**TOWN AND COUNTRY PLANNING ACT 1990 (AS AMENDED)
SECTION 96A (NON-MATERIAL AMENDMENT) APPLICATION TO PLANNING PERMISSION
REF: 2025/62/92598/E FOR MINOR AMENDMENTS TO FLOOR PLANS, ELEVATIONS, SITE
PLAN, AND ELECTRIC VEHICLE CHARGING CONDITION
CO-OP ACADEMY SMITHIES MOOR, LEEDS OLD RD, HECKMONDWIKE, WF16 9BB
PLANNING PORTAL REF: PP-15201862**

The application proposes minor changes to the floor plans, elevations and site plan, as well as to the electric vehicle charging condition (Condition 13), as approved by planning permission ref: 2025/62/92598/E.

Planning GA Level RF

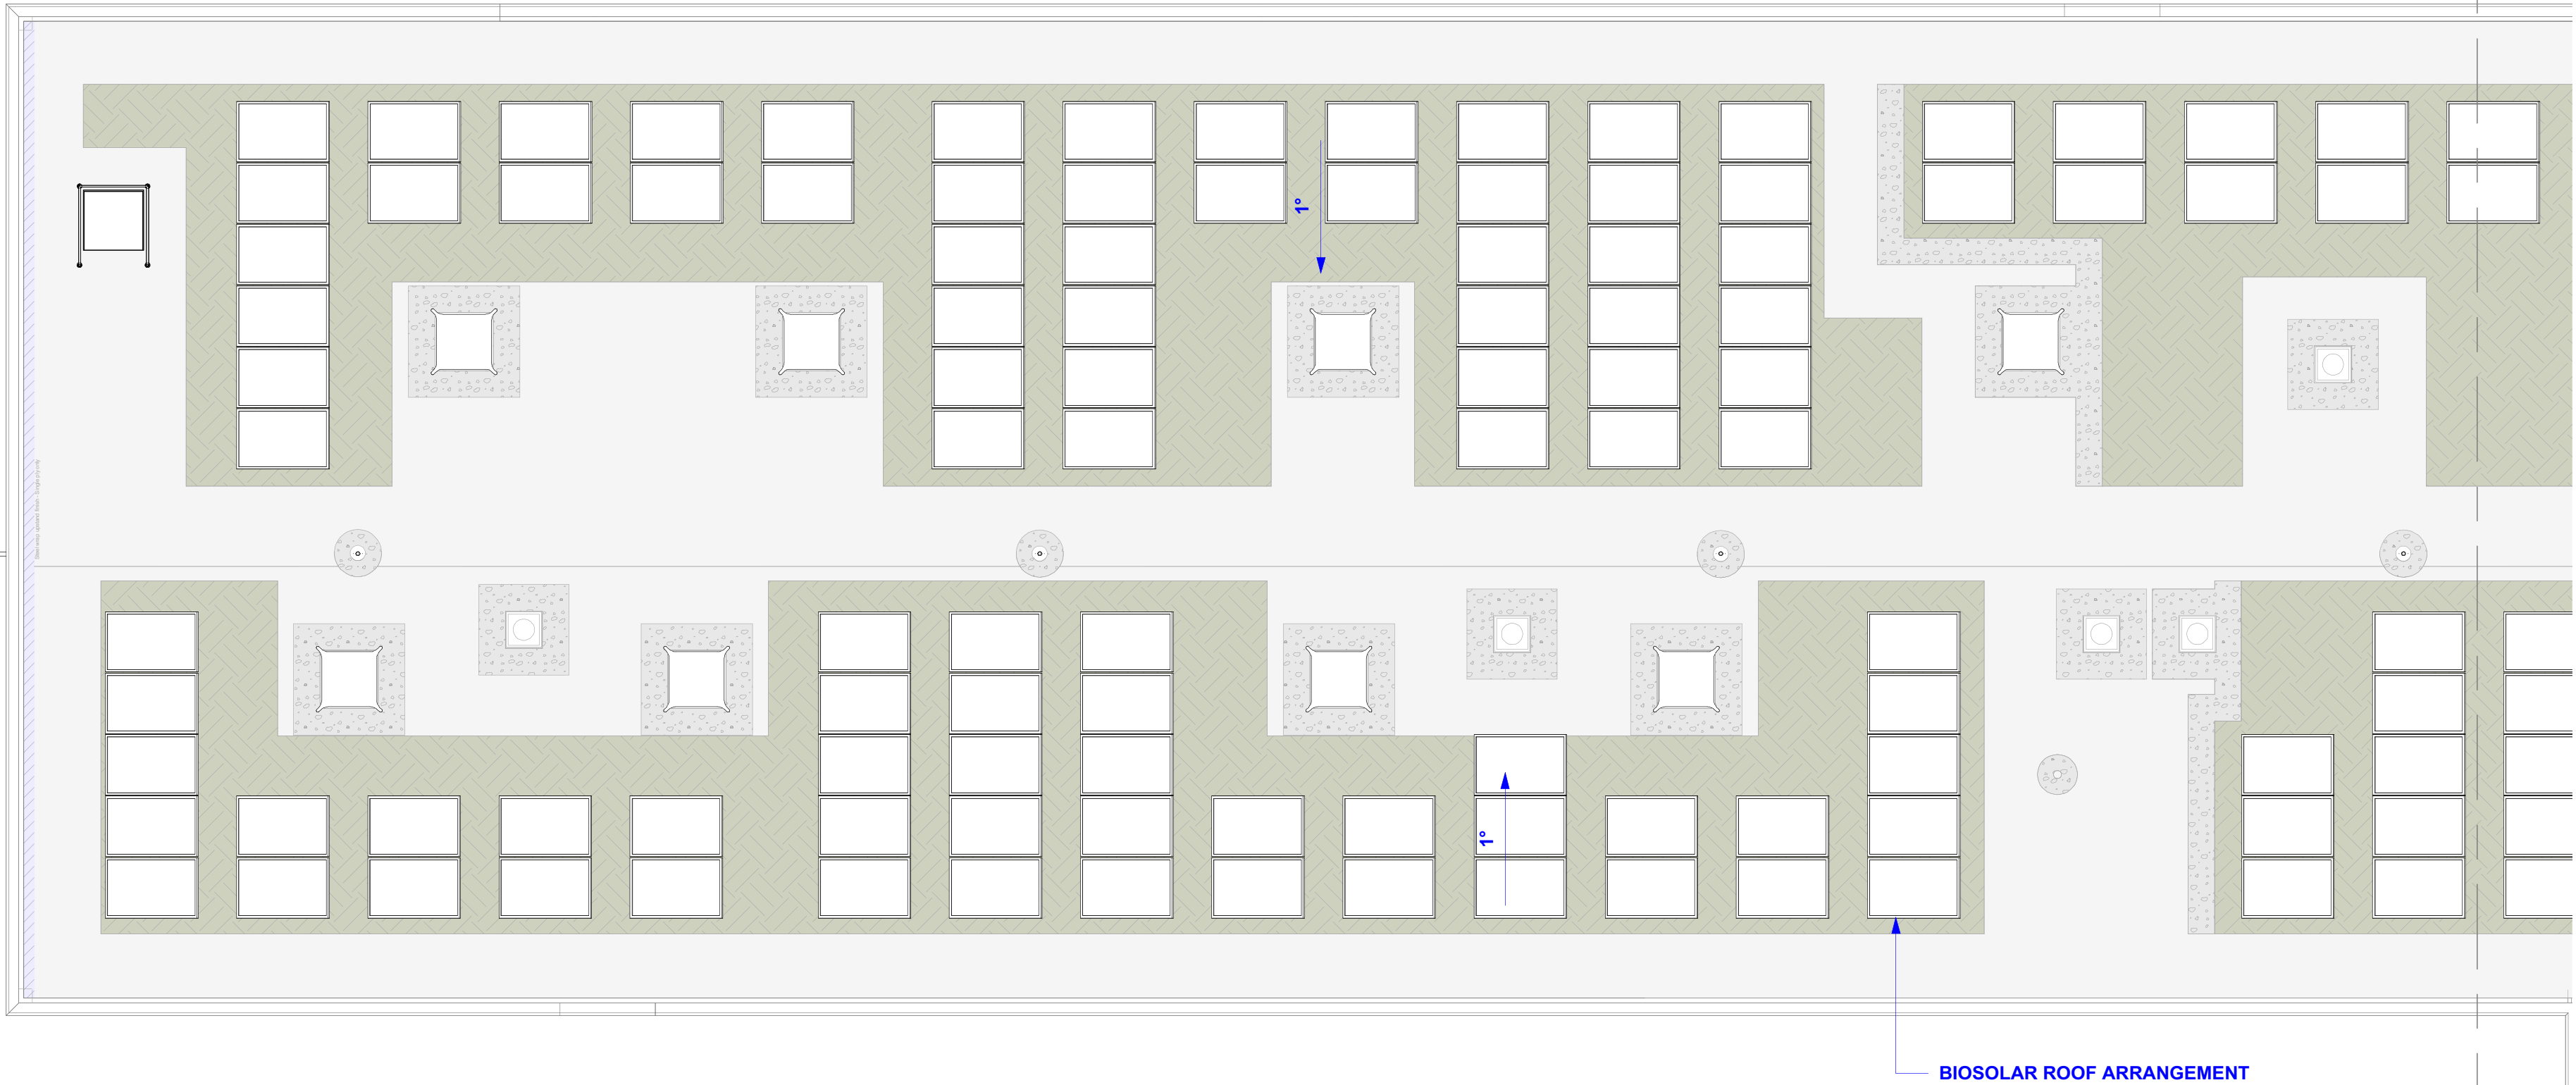
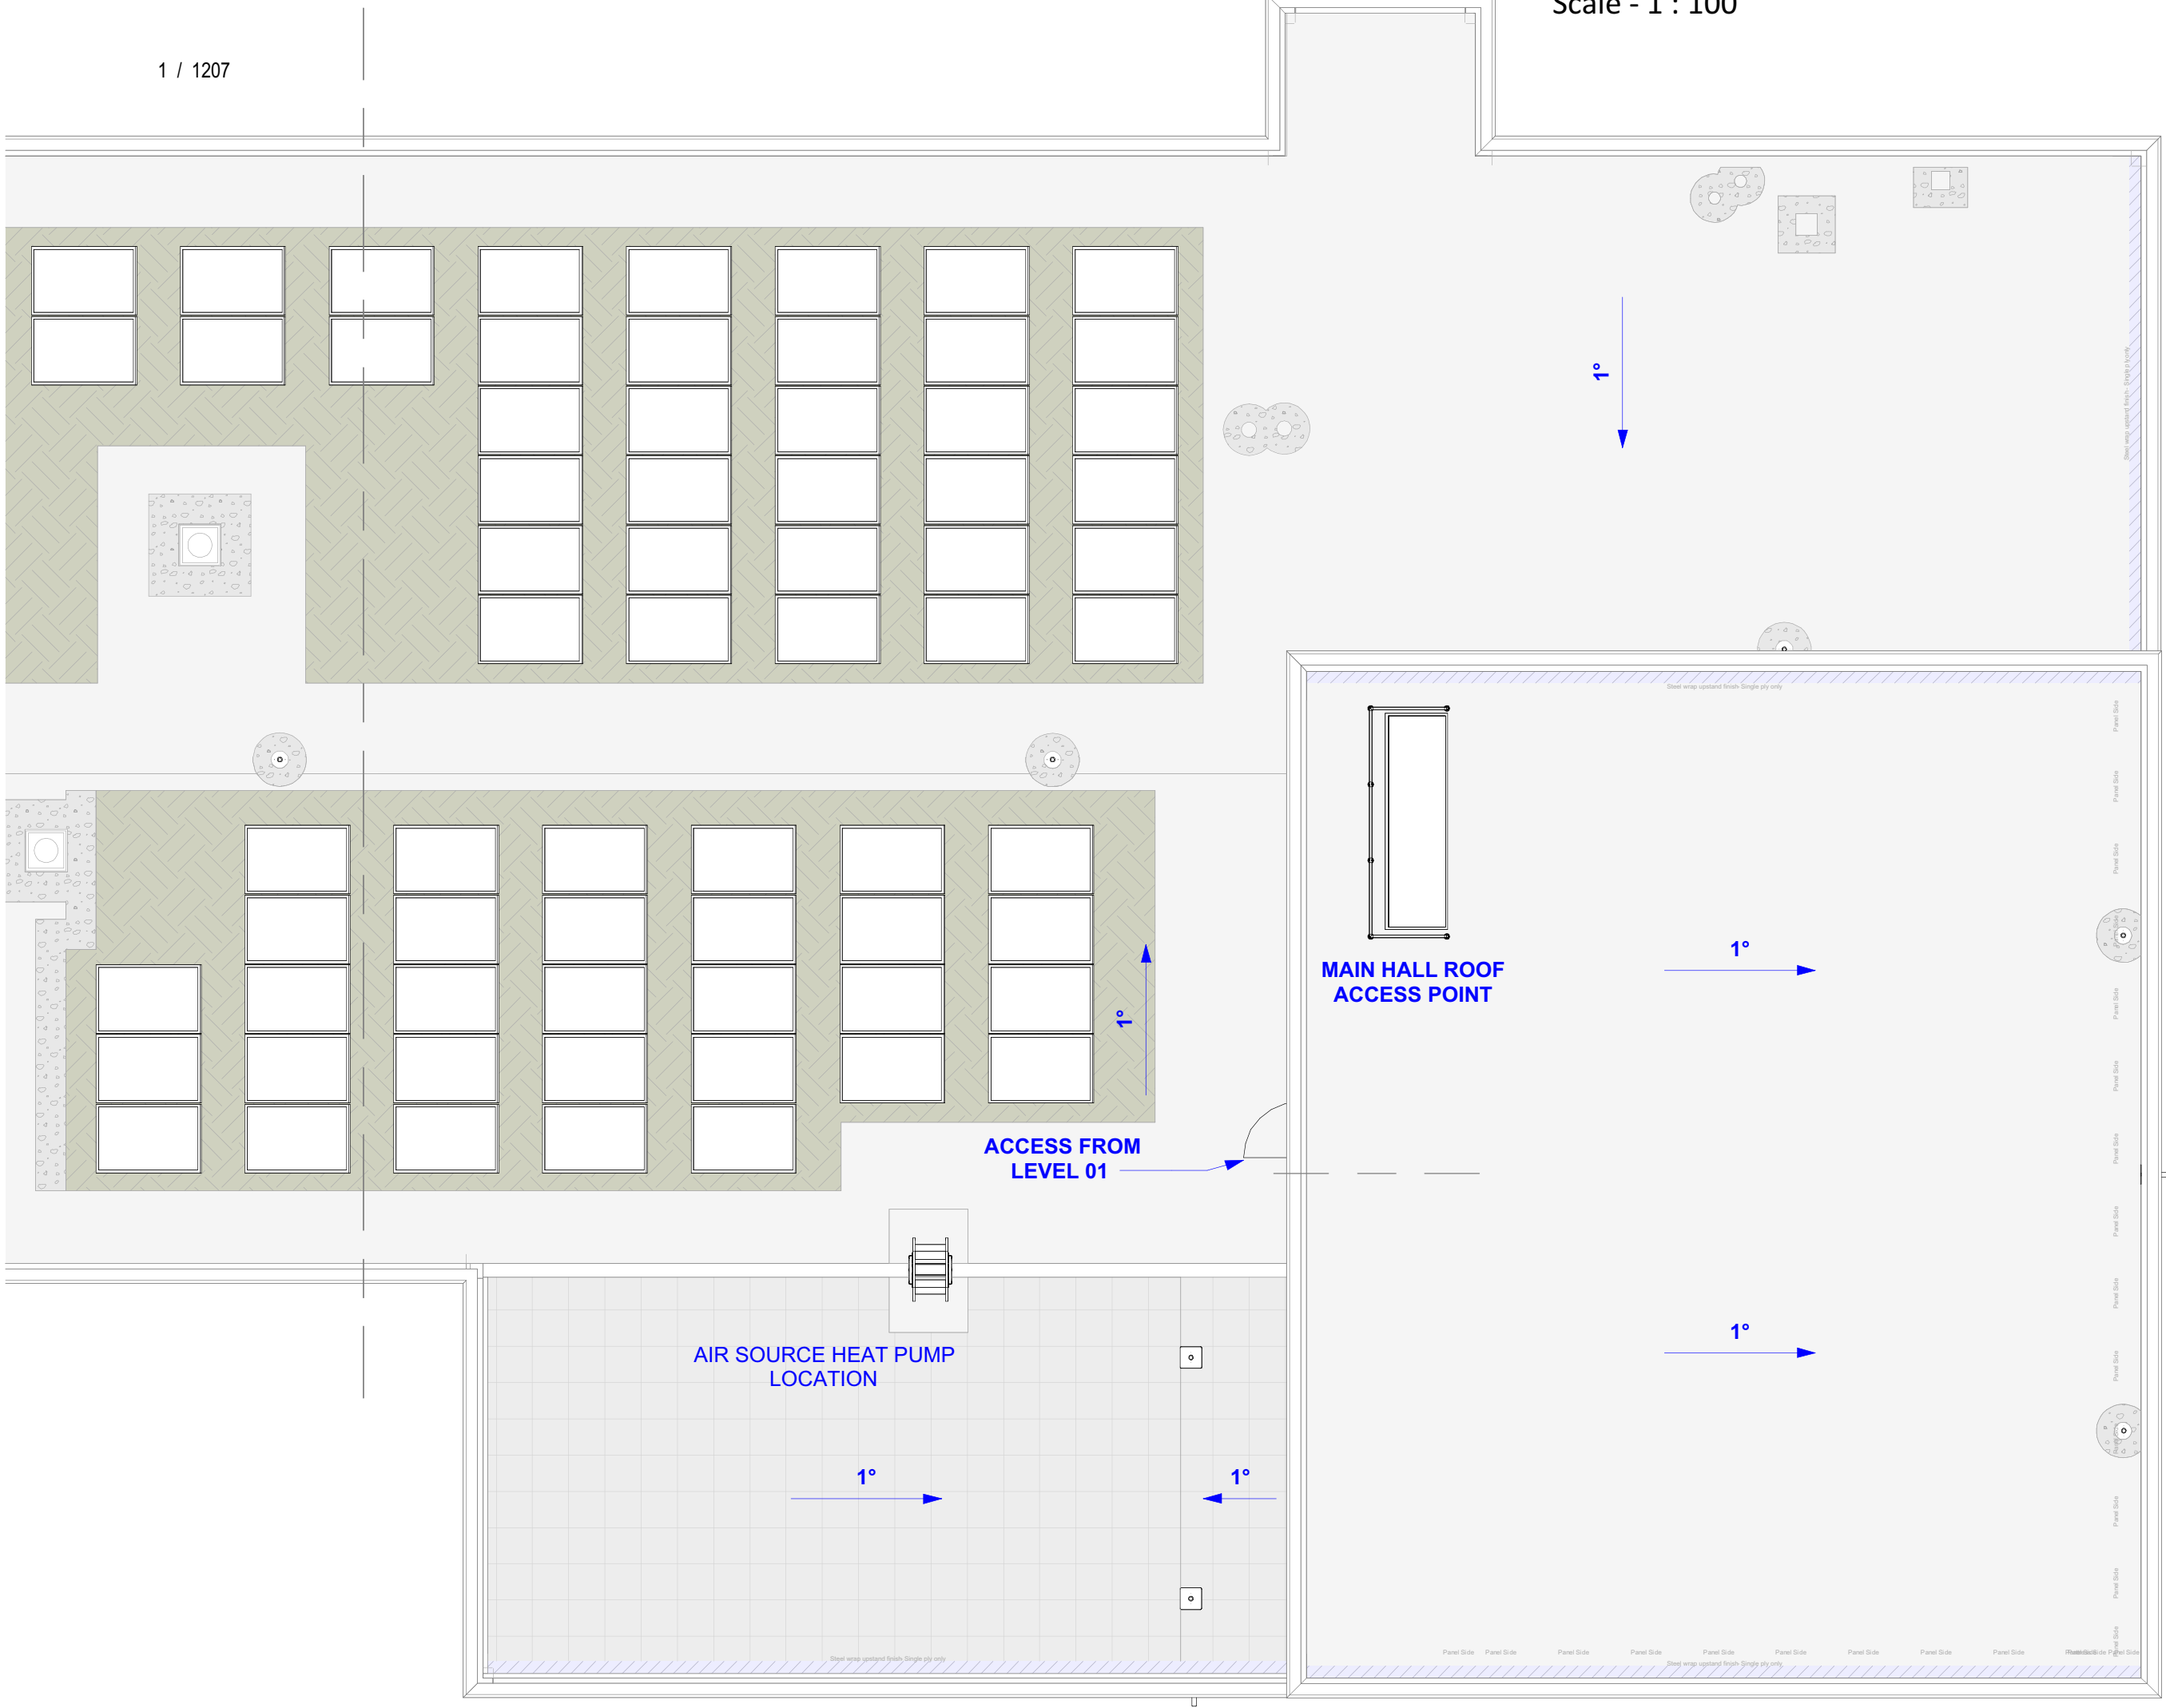
Elevations and Roof Plan: The elevations and roof plan have been updated to reflect the final detailed design of the approved development. This includes the confirmed location of rooftop MEP equipment, approved external materials, bird and bat boxes and minor refinements to brick coursing details around building corners.

The rooftop MEP equipment was shown indicatively on the approved drawings and is now shown in its confirmed form and location for completeness. Similarly, the external materials and the provision of bird and bat boxes have been updated to reflect the details approved by discharge of condition application 2026/90790 and the approved Biodiversity Enhancement Plan.
